## Fire Marshal Division

**Re: Domino's (Inside Wal-Mart)  
2800 NC 24/87  
Cameron, NC 28326**

**Application Number BCOM2008-0003**

<b>PROJECT NAME &amp; ADDRESS:</b> Domino's 2800 NC 24/87 Cameron, NC 28326
--

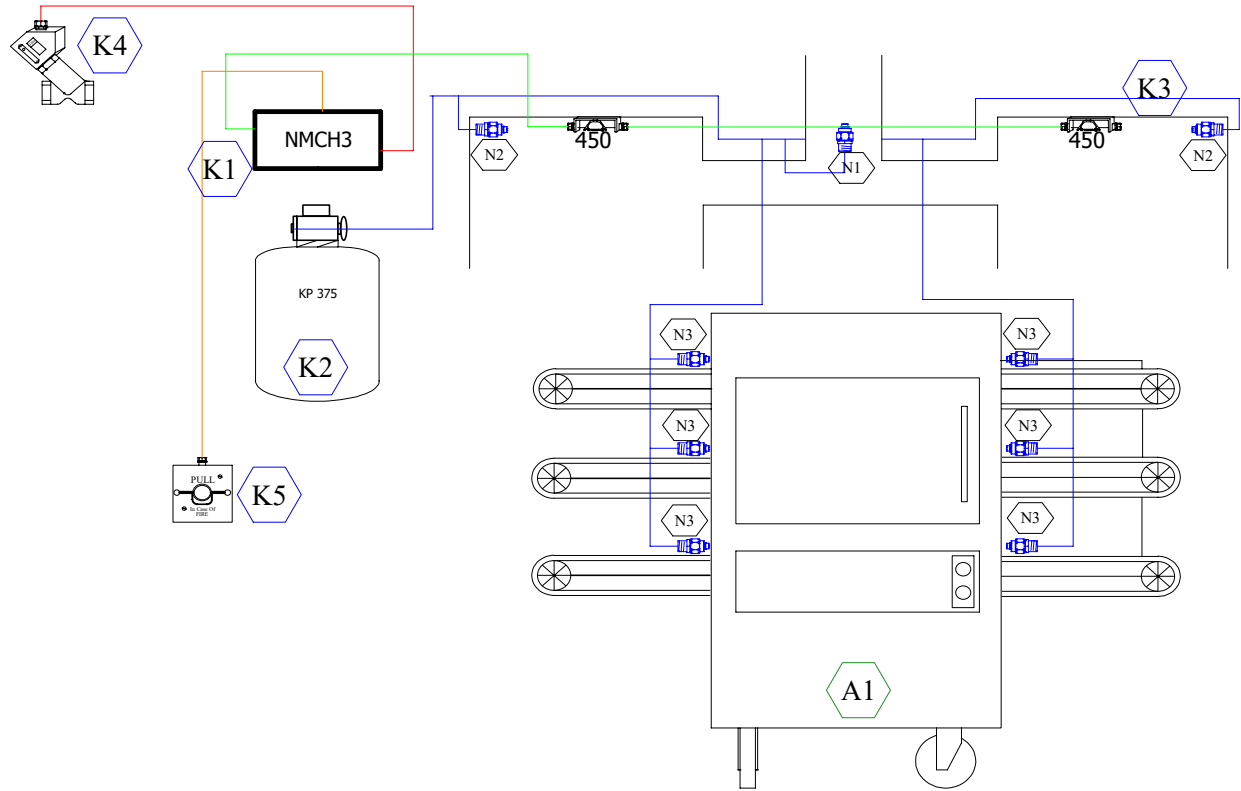
- **Commercial cooking equipment**
  - Portable fire extinguishers shall be provided within a 30-foot (9144 mm) travel distance of commercial-type cooking equipment. Cooking equipment involving vegetable or animal oils and fats shall be protected by a Class K rated portable extinguisher.
- **Acceptance Test**
  - An acceptance test will be conducted by the Fire Marshal's office once system has been installed and pre-tested.
  - Installation shall be per architectural and system submittals and compliant with NFPA-17A.
- **Manual system operation**

- A manual actuation device shall be located at or near a means of egress from the cooking area, a minimum of 10 feet (3048 mm) and a maximum of 20 feet (6096 mm) from the kitchen exhaust system.

- The manual actuation device shall be located a minimum of 4.5 feet (1372 mm) and a maximum of 5 feet (1524 mm) above the floor. The manual actuation shall require a maximum force of 40 pounds (178 N) and a maximum movement of 14 inches (356 mm) to actuate the fire suppression system.
- The actuation of the fire suppression system shall automatically shut down the fuel or electrical power supply to equipment under the hood system. The fuel and electrical supply reset shall be manual.

- **System Interconnection**
  - The actuation of the fire suppression system shall automatically shut down the fuel or electrical power supply to any equipment under the hood system. The fuel and electrical supply reset shall be manual.
